# Rezoning Transportation Analysis

Petition Number: 2020-109

## Revision Log:

Date	Description
09-18-20	First Review (LJ)
10-19-20	Second Review (LJ)
11-30-20	Third Review (LJ)
12-28-20	Fourth Review (LJ)
01-28-21	Fifth Review (LJ)

EX01-REZONING PLAN

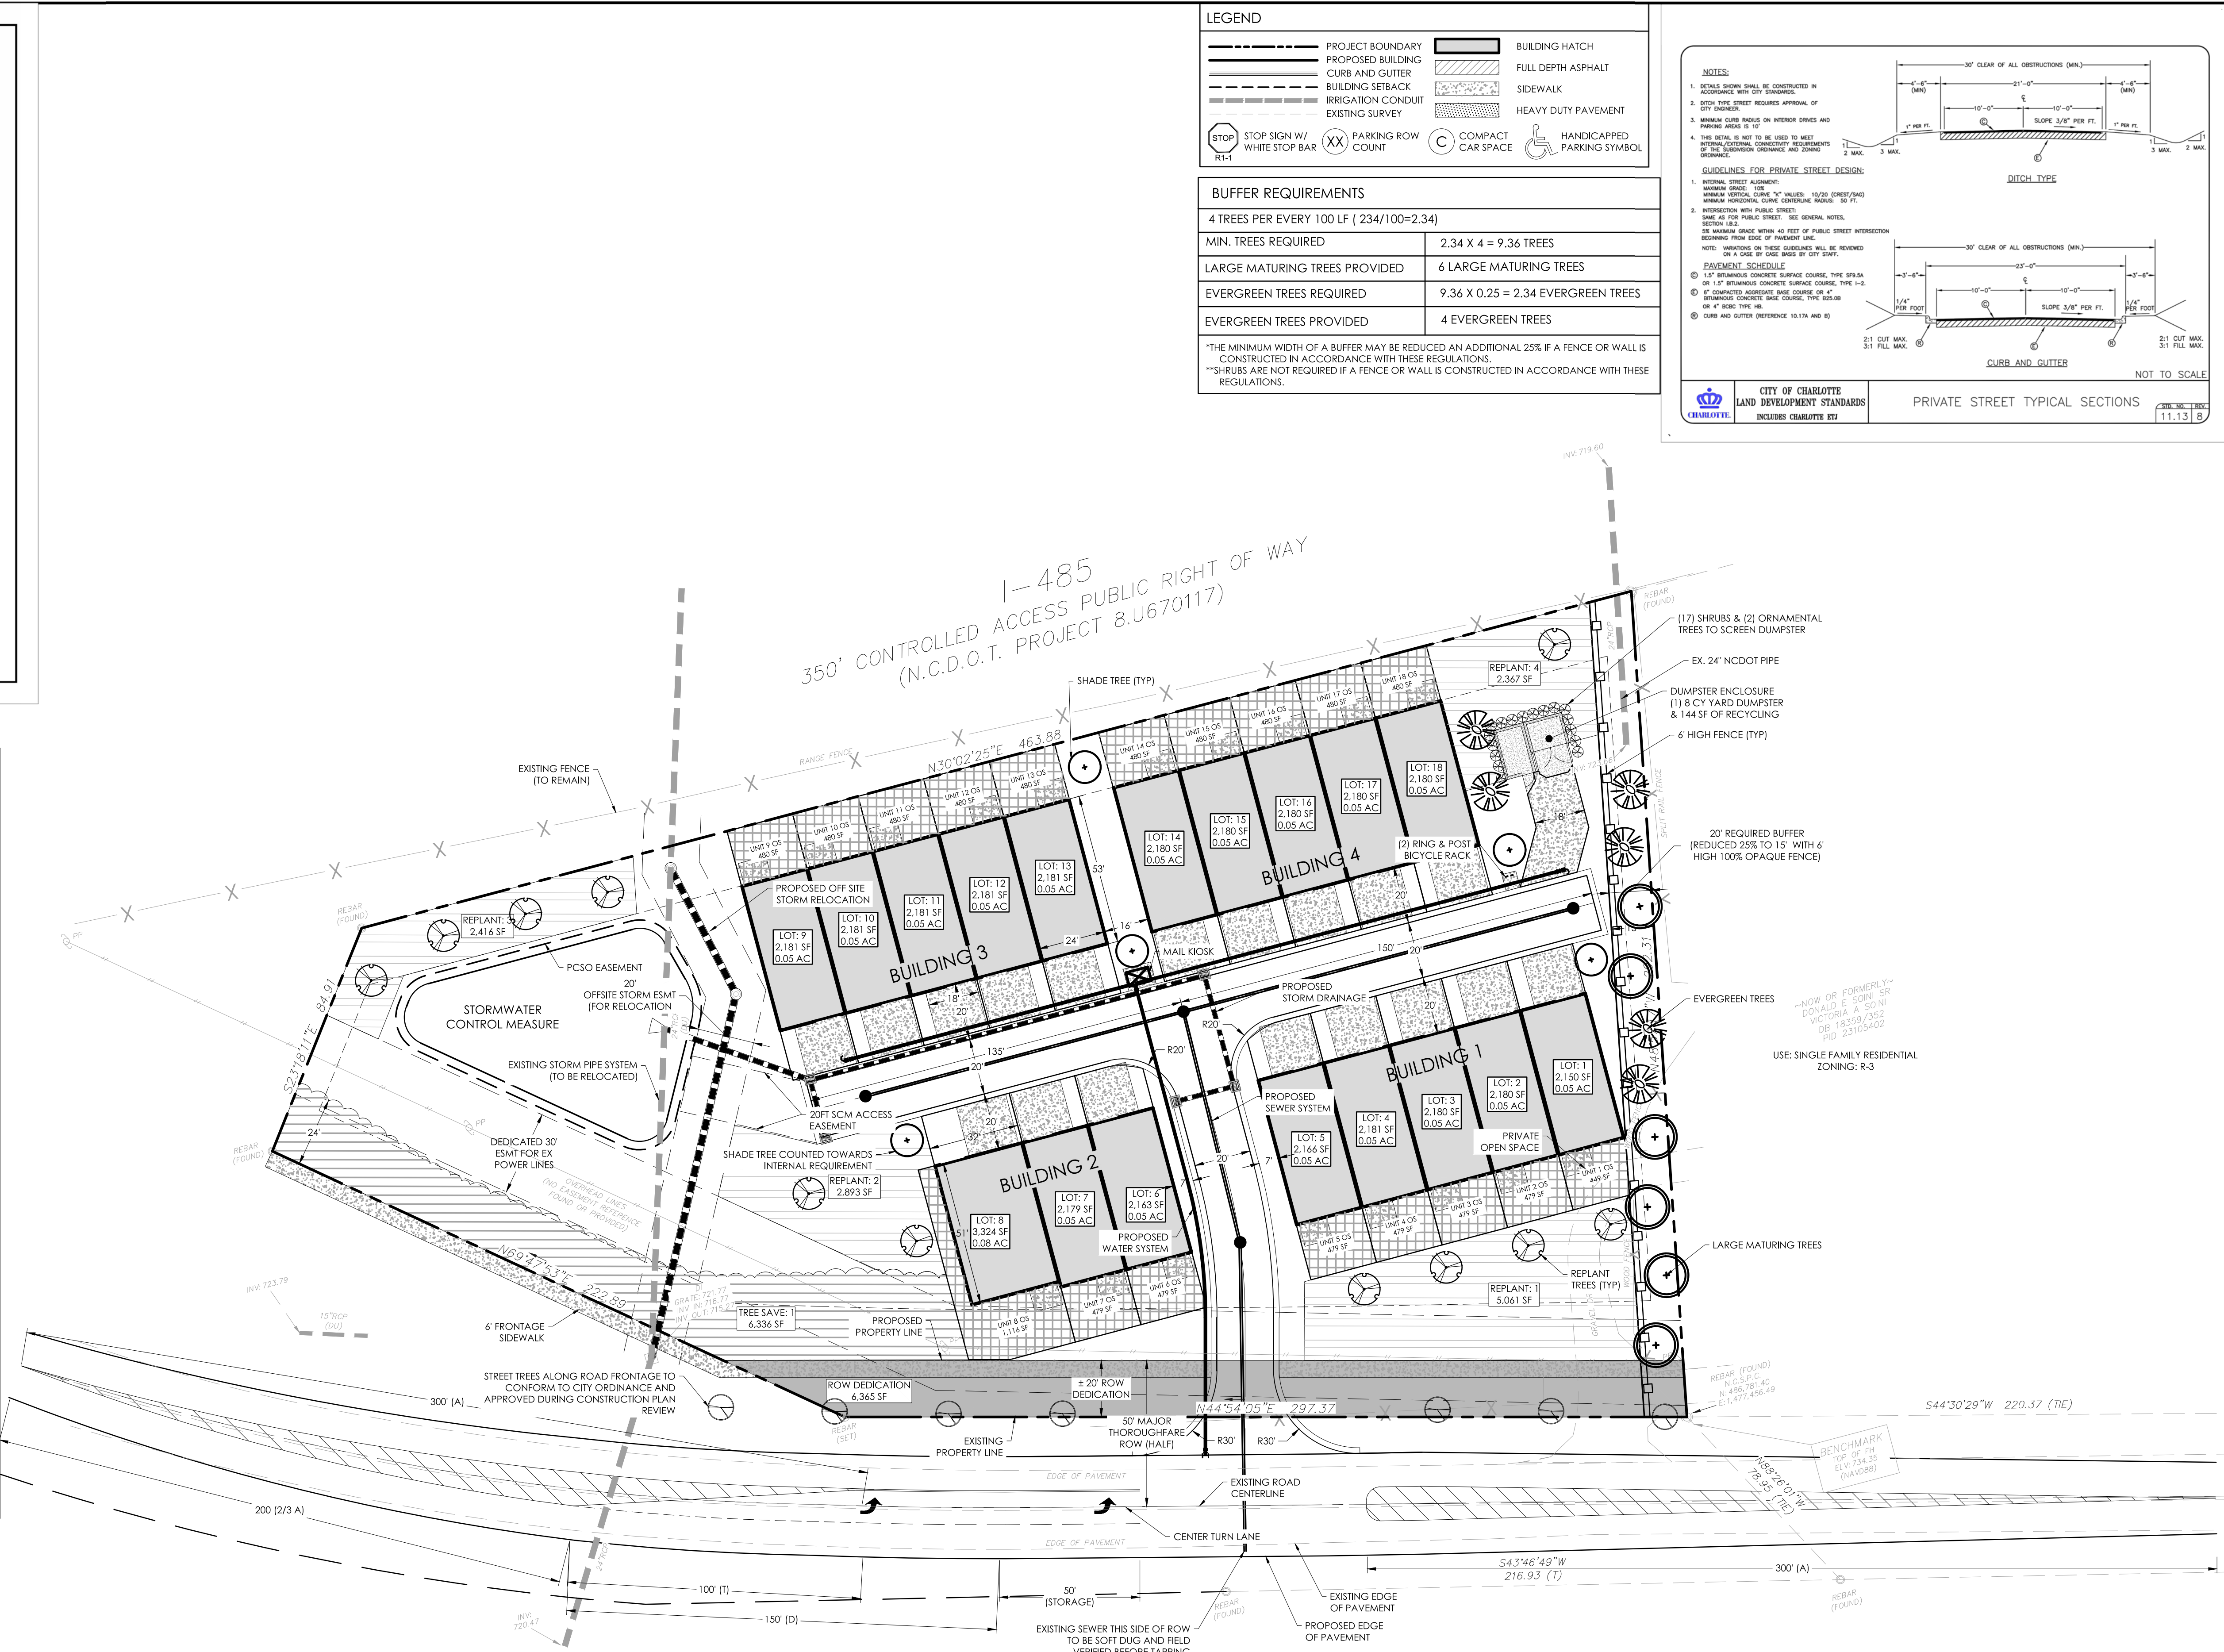
~~**McKee Road (NCDOT):** The future location of back of curb and gutter is 30' from the McKee Road centerline. The curb and gutter needs to be labeled and dimensioned from the road centerline to the back of curb on the site plan.~~

~~3. **Rescinded (01/28/2021):** The site plan and conditional note(s) need to include an 8-foot planting strip on McKee Road per Chapter 20/Chapter 19. CDOT requests a 12-ft Multi Use Path in lieu of the required 6-foot sidewalk per the Charlotte BIKE Policy (primarily due to land use context and lack of frequent driveways). Both items need to be labeled and dimensioned from the back of curb and gutter and road centerline on the site plan.~~

~~4. Pedestrian sight triangles (NCDOT 10'x70') at the McKee Road driveway connection need to be reflected on the site plan. Label all roadways as private streets, where appropriate.~~

~~6. **(Revised 10/19/20):** Petitioner to relocate the inner crosswalk to alleviate the diagonal crosswalk at the 3-legged intersection.~~

~~7. **(Revised 10/19/20):** Petitioner to provide a 100' driveway stem from NCDOT ROW line, as per NCDOT standards.~~

The site is located on McKee Road, a major thoroughfare (State-maintained) road. The petitioner has committed to an 8' planting strip and 6' sidewalk in accordance to Chapter 20 of the subdivision ordinance and Charlotte WALKS plan. The site has provided a private drive for access to the residential units and provides an internal 5' sidewalk for connectivity. CDOT comments have been successfully resolved.
